DRAWN BY: D.E. WATTS DATE: 12-10-20 DWG. NO.: 20-5564-01 SURVEYED BY: DEV, ESS, 12-10-20	APPROVED BY: PROJ. NO.: DWG.:	REVISIONS:	OLIVER E. WATTS CONSULTING ENGINEER COLORADO SPRINGS	PROJECT: 16810 SOUTH PEYTON HIGHWAY PART NE S8, T.17S., R.63W., 6TH P.M. EL PASO COUNTY, COLORADO	SHEET NAME: SITE PLAN	SHEET NO.: 1 OF 1
---	-------------------------------------	------------	--	--	---------------------------------	----------------------------

Landscape Plan_V1.pdf Markup Summary

Subject: Environmental
Page Label: 1
Author: Sophie Kiepe
Date: 4/2/2021 3:10:25 PM
Status:
Color: ■
Layer:
Space:

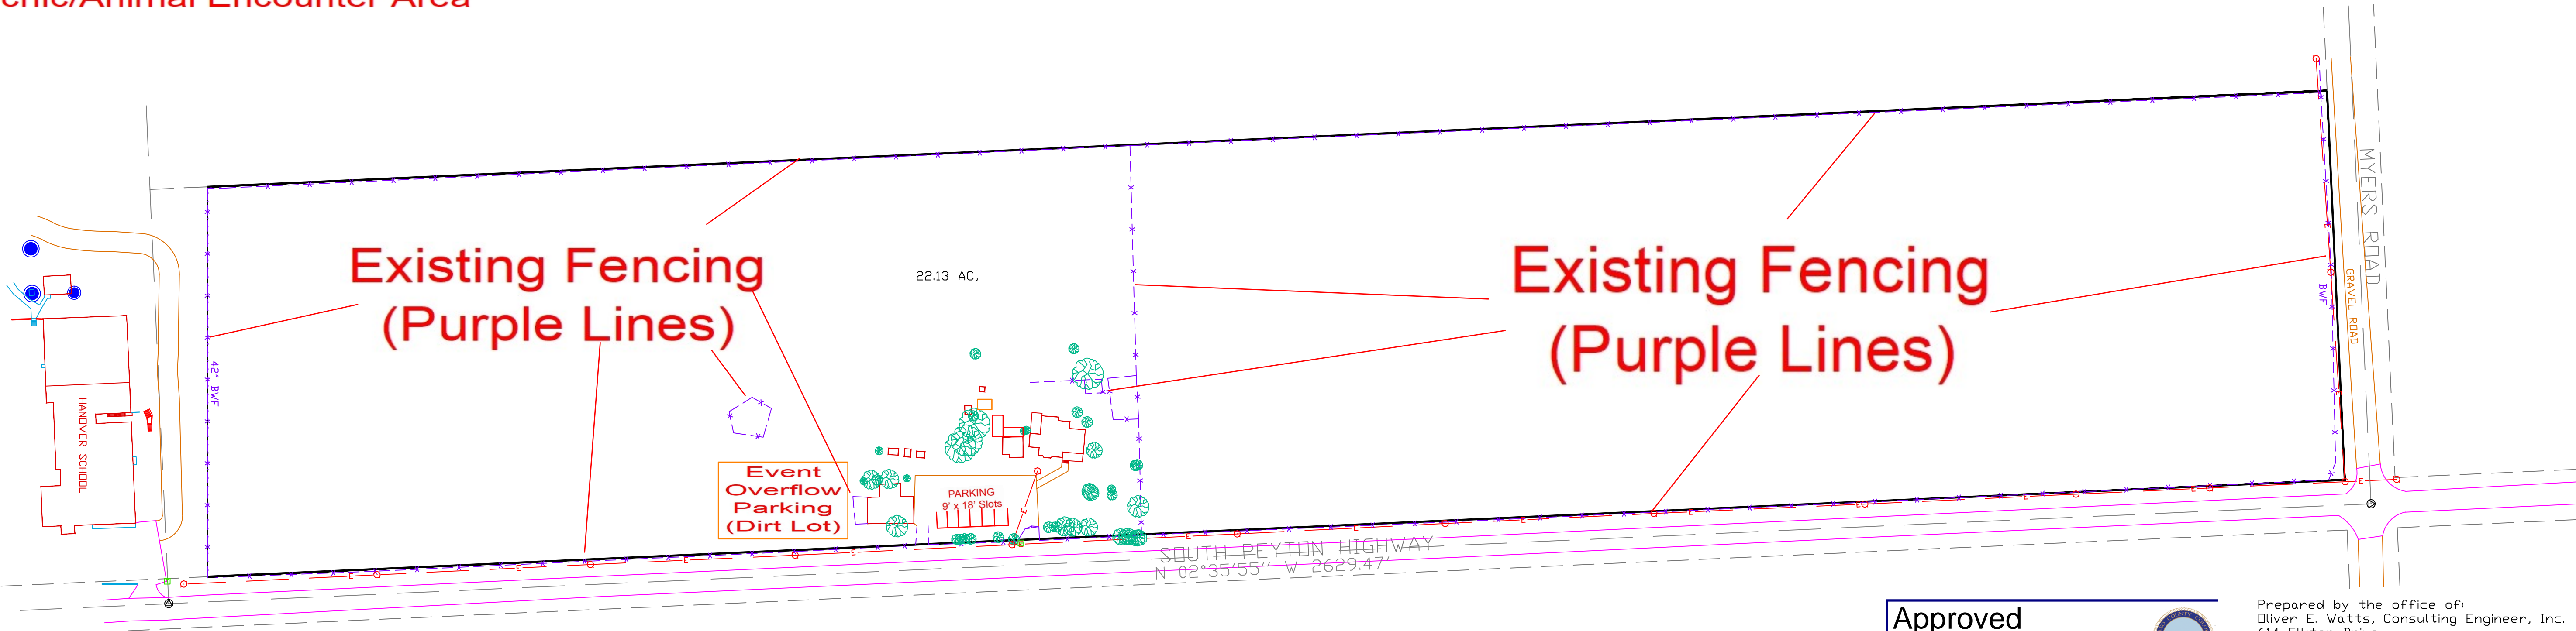
Landscape Requirements in Ch. 6 apply per the Applicability subsection and are not being met. I have attached the landscape requirements from the Code within the EDARP comments, please refer to them and revise the landscape plan accordingly.

Alternatively, if landscape requirements in Chapter 6 (attached to comment provided in EDARP) will not be met, then please request an alternative landscape plan in the letter of intent and justify it by explaining how the proposed landscaping meets the purpose of the code and promotes the concepts contained in the Landscape and Water Conservation Manual.
